KIRKLEES METROPOLITAN COUNCIL INVESTMENT & REGENERATION SERVICE

DELEGATED DECISION TO DETERMINE APPLICATIONS FOR LISTED BUILDING CONSENT

Reference No:	2023/65/90043/W
Site Address:	The Farmhouse, Carr Farm, Uppergate, Hepworth, Holmfirth, HD9 1TG
Description:	Listed Building Consent for erection of single storey extension with associated works and solar panels (Listed Building within a Conservation Area)
Recommending Officer:	William Simcock

Officer Report – The Farmhouse, Carr Farm, Hepworth 2023/90043 – Listed Building Consent

DWG NO.	(PL)001	TITLE	Proposed Floor Plans
SCALE	As shown	SIZE	A1
DRAWN/CKD	JF / HE	DATE	16/12/2022

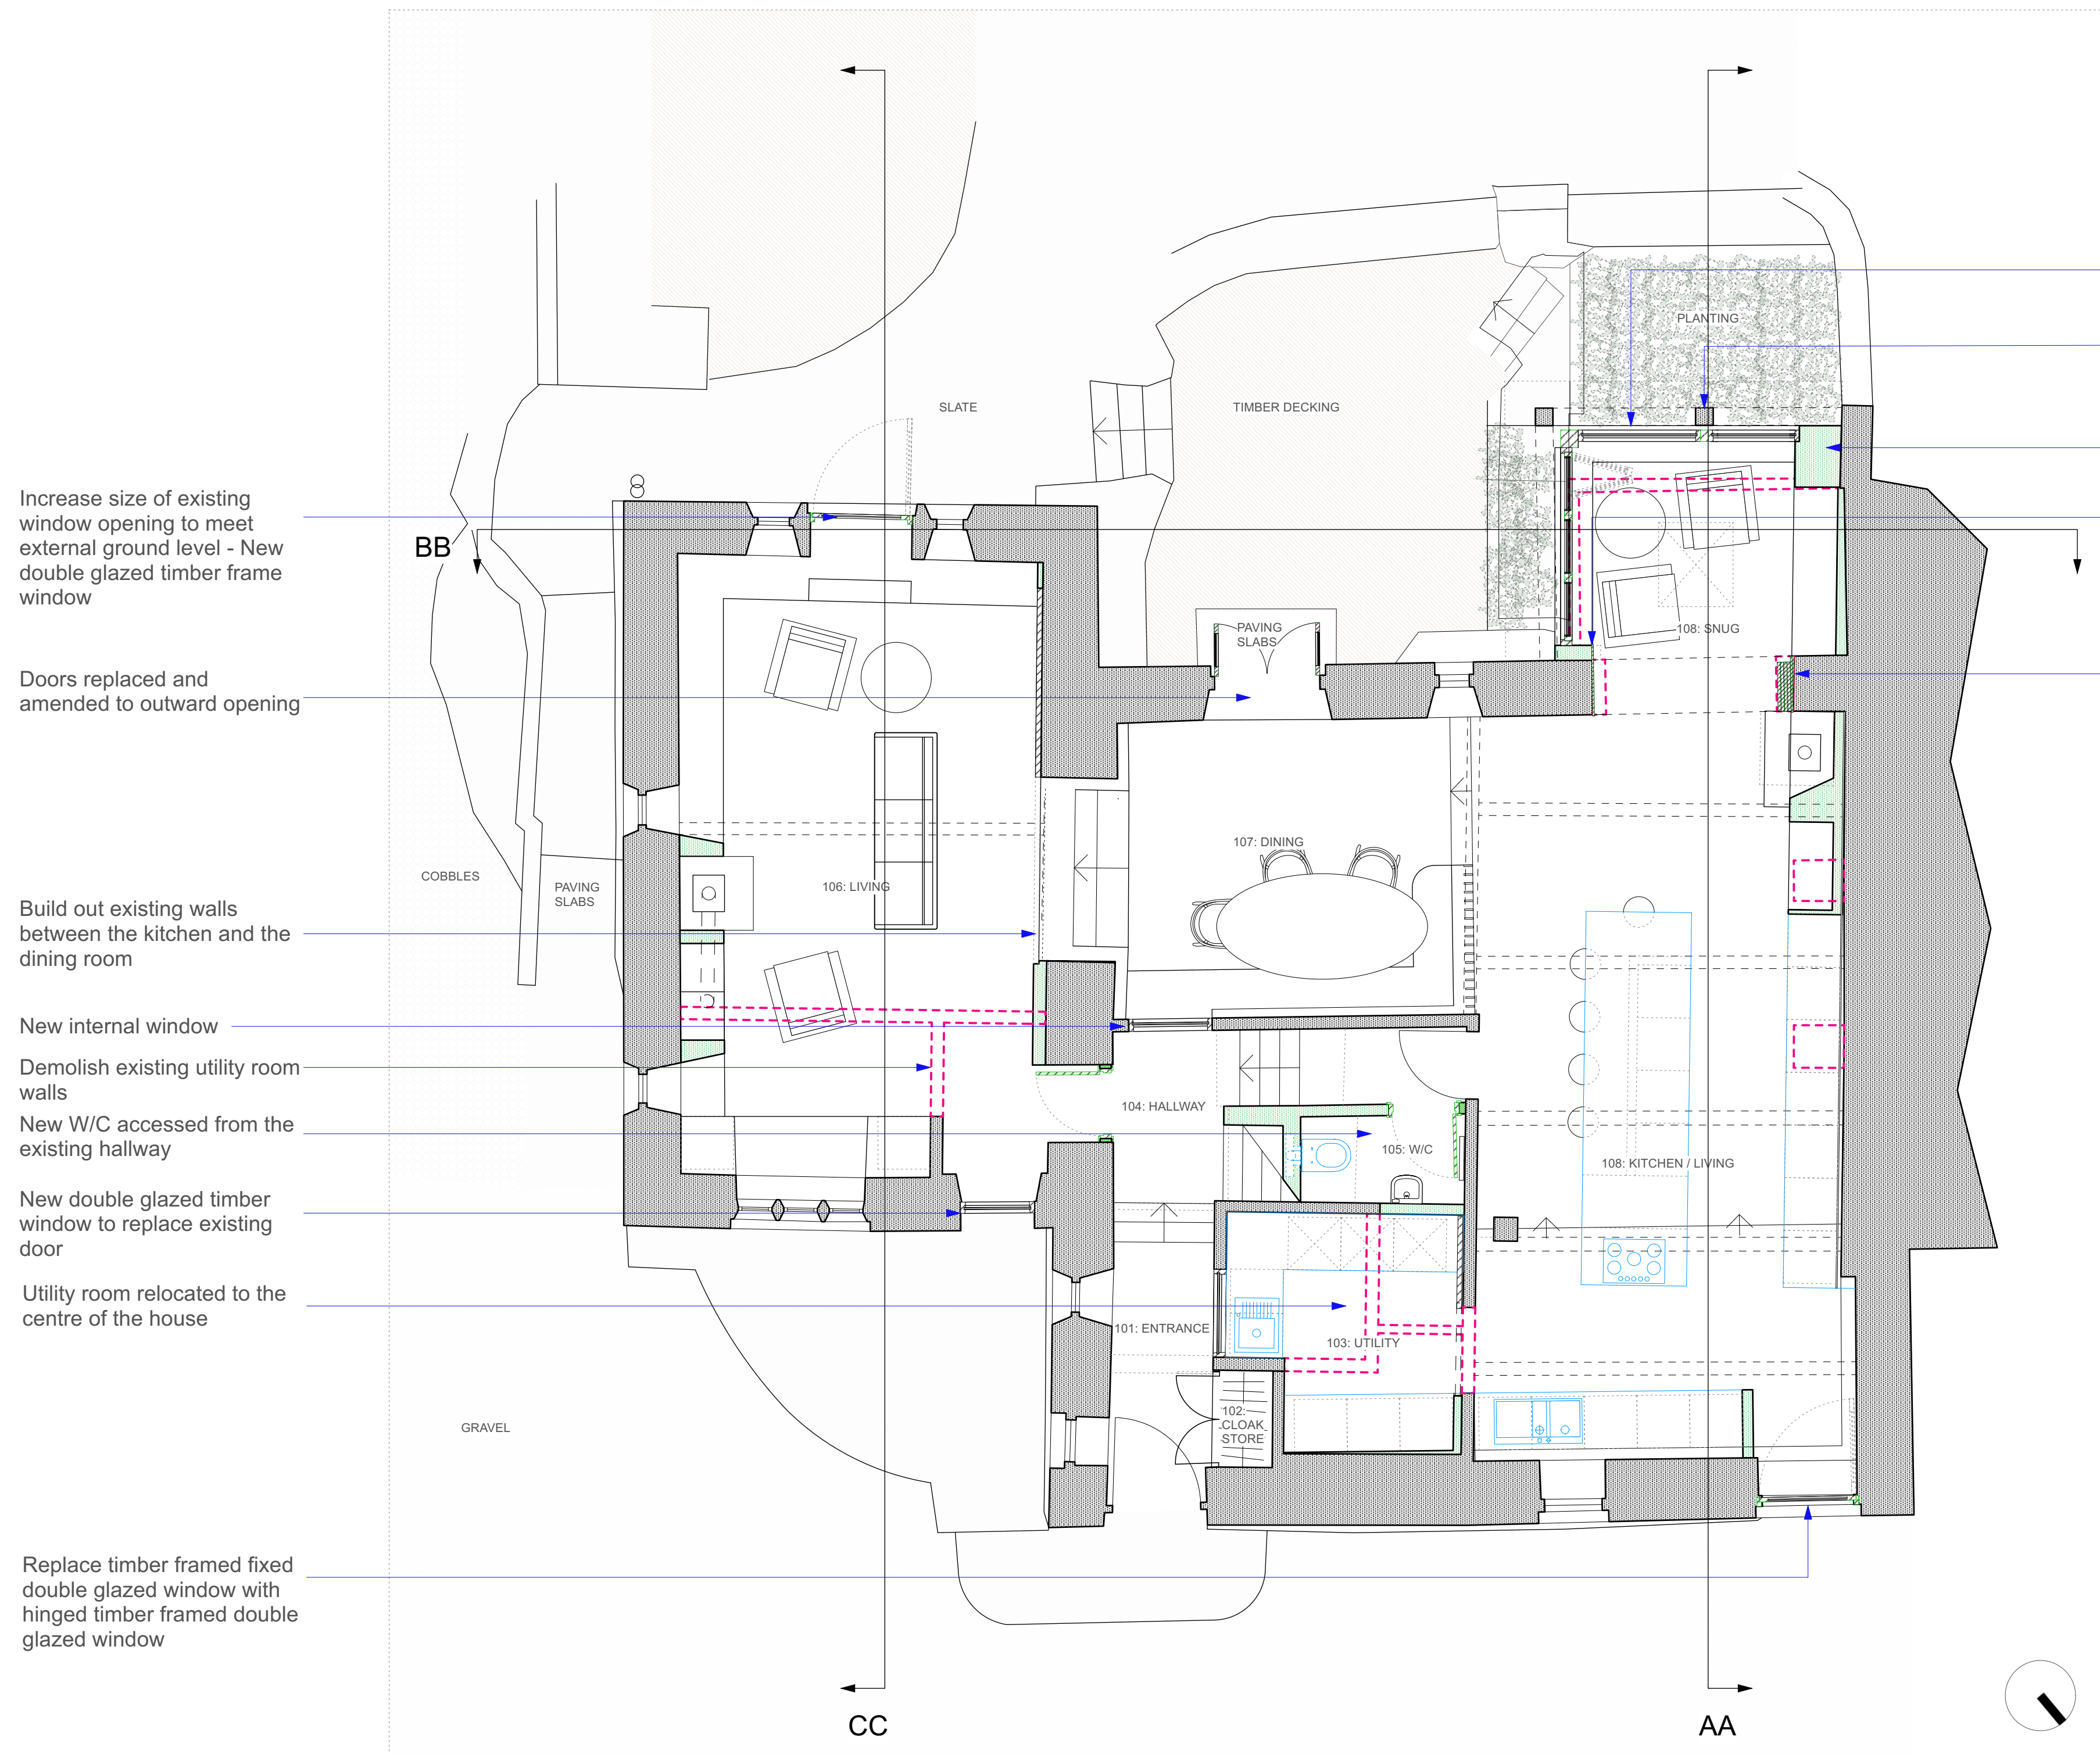
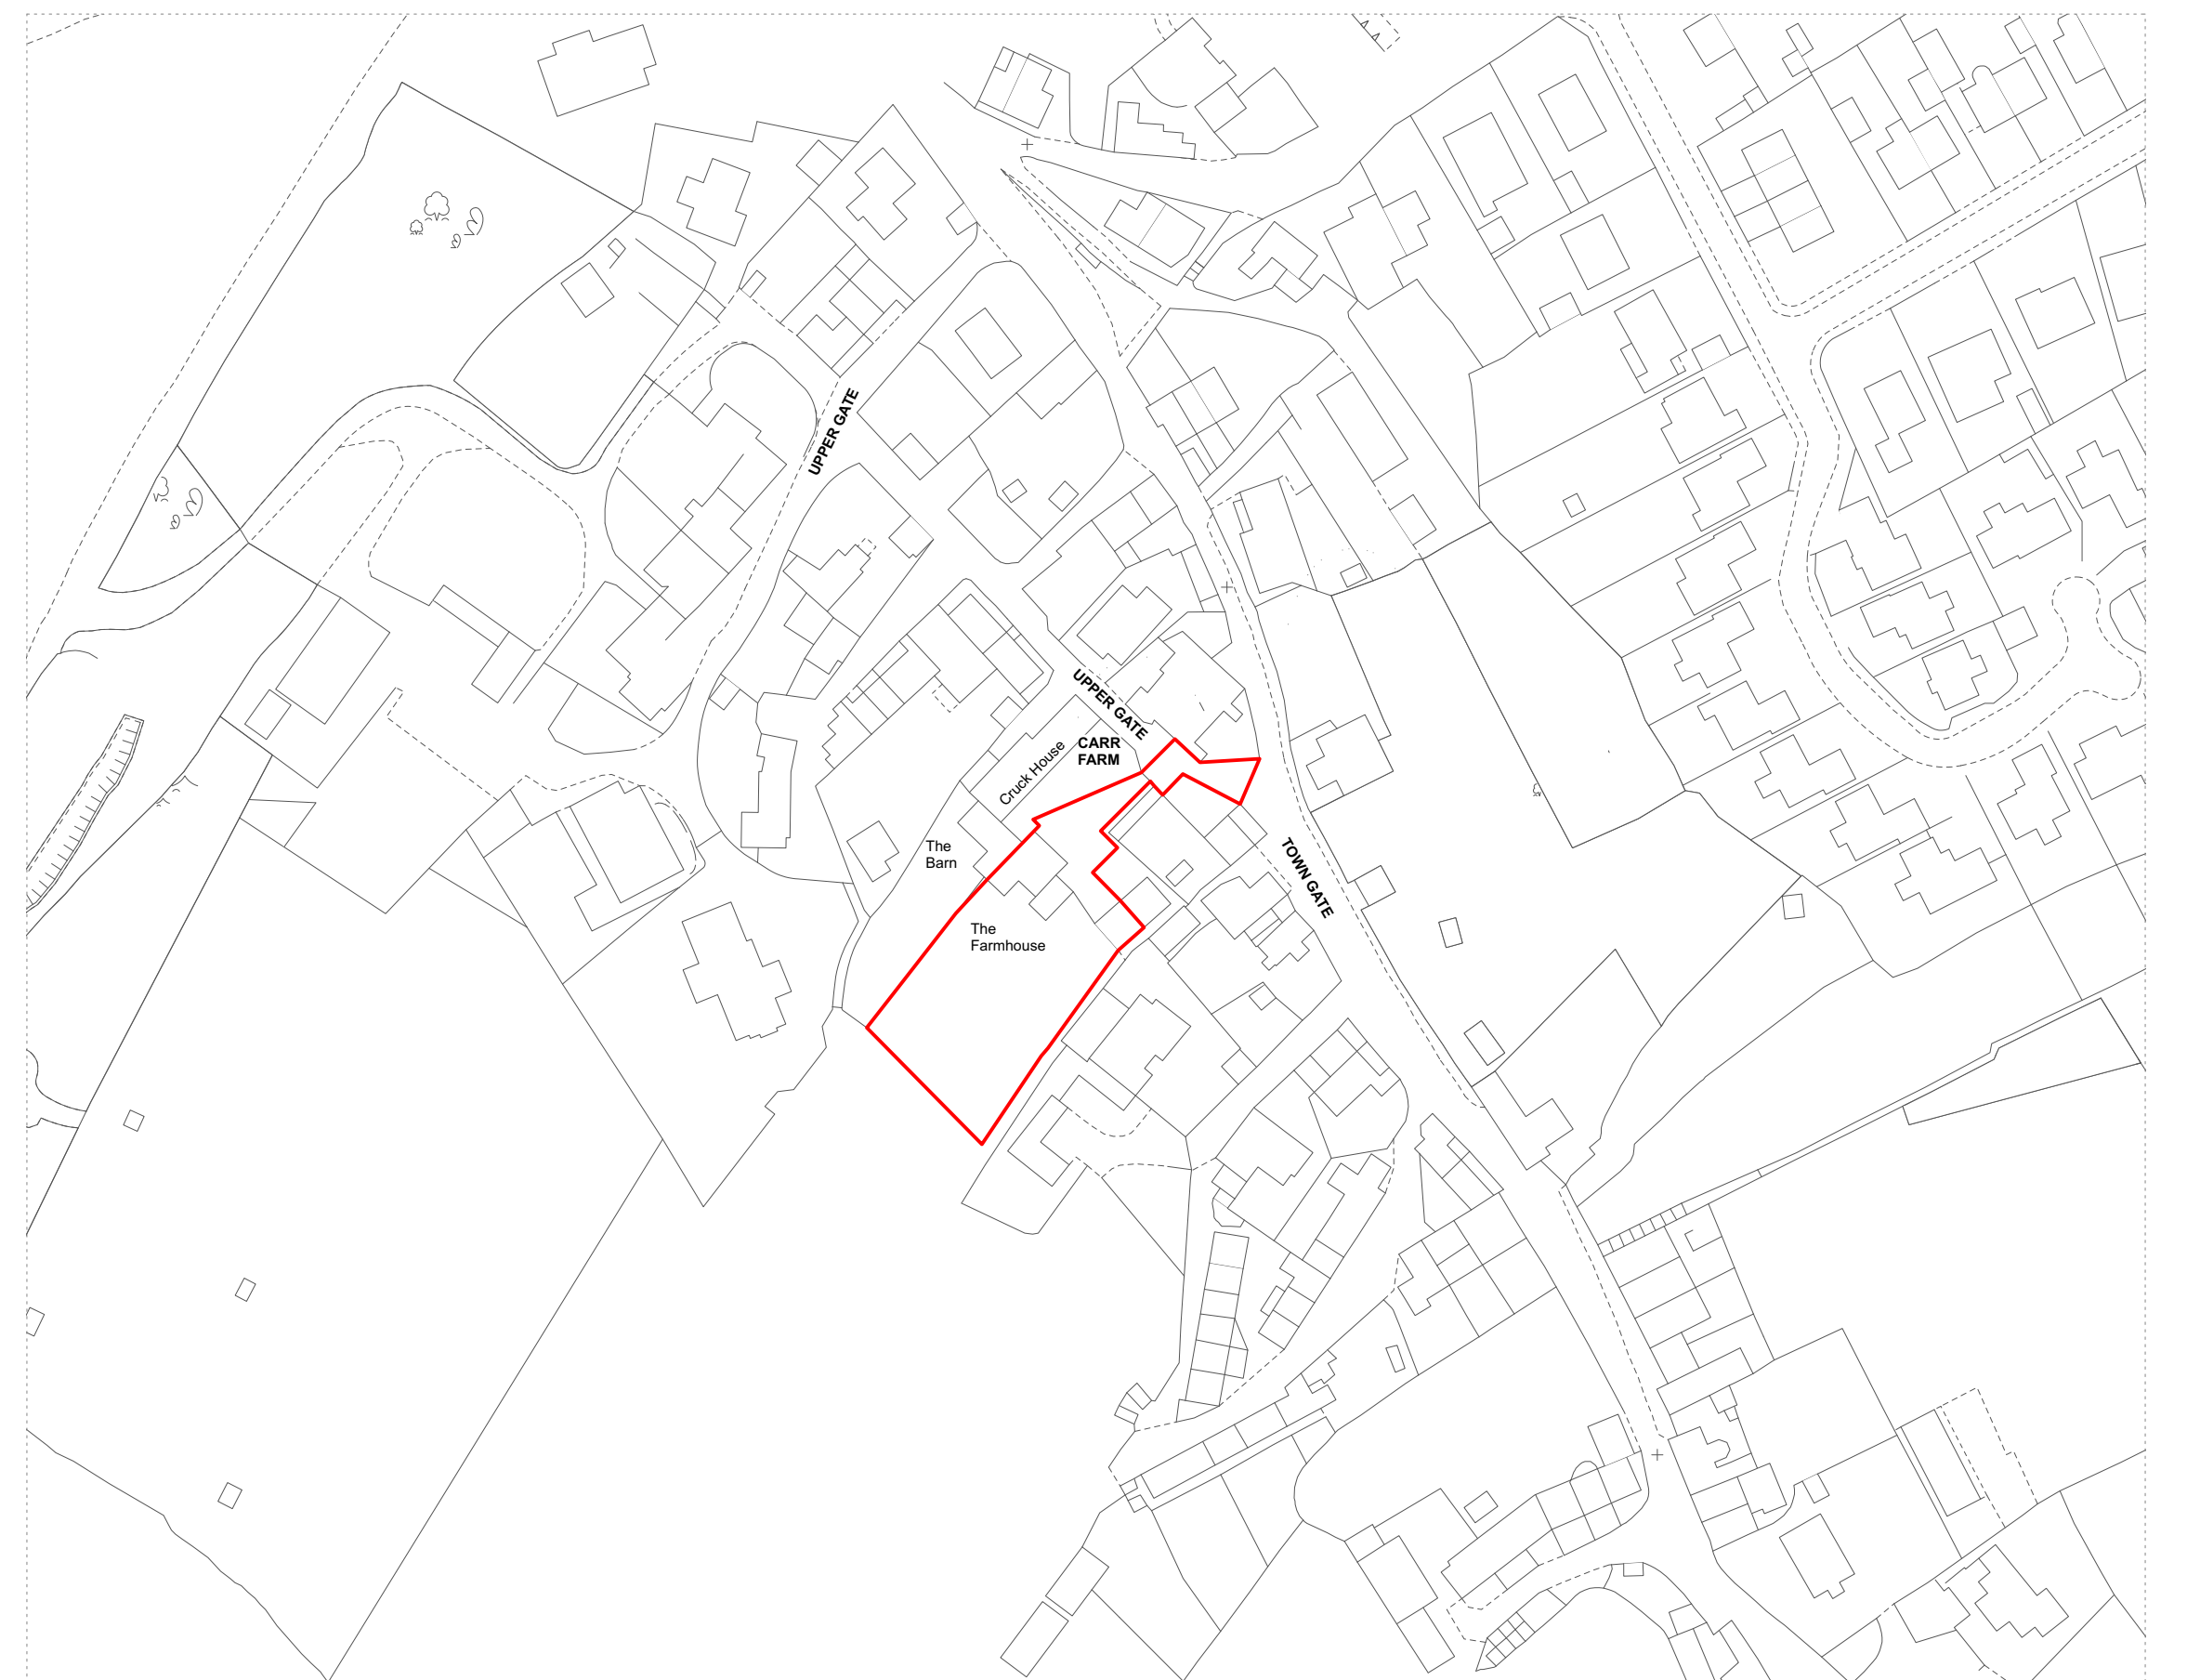
2 – Impact on character and significance of Listed Building: The proposed works to the external appearance include the alterations to the existing single storey rear extension. Currently a glazed structure under a lean-to roof supported by timber posts. The proposal is to increase the footprint of the extension to the supporting posts, which will be retained along with the existing roof structure. Given that the structure is existing and a later addition at the time of the conversion, the small increase in footprint is acceptable. Albeit the bifold doors and large floor to ceiling windows are not traditional in their design the use of timber is acceptable and given they will sit within the existing frame, the proposal will have a minimal effect on the character of the Listed Building.

The external alterations also include the changing of one of the front doors into a floor to ceiling window and the existing floor to ceiling window in the proposed kitchen change to an opening window. On the rear elevation the existing central kitchen window will be extended to the floor to create access into the rear garden. Again, these elements are acceptable as the alterations to the front are to existing openings and the rear elevation is a new window at the time of the conversion therefore, these alterations would have limited impact on the Listed Building.

5. Notwithstanding the submitted details any replacement double glazing units shall be of no greater thickness than 16mm with a build-up of 4mm – 8mm – 4mm and shall use black edge spacers.

6. Window frames shall be recessed a minimum distance of 75mm from the face of the building.
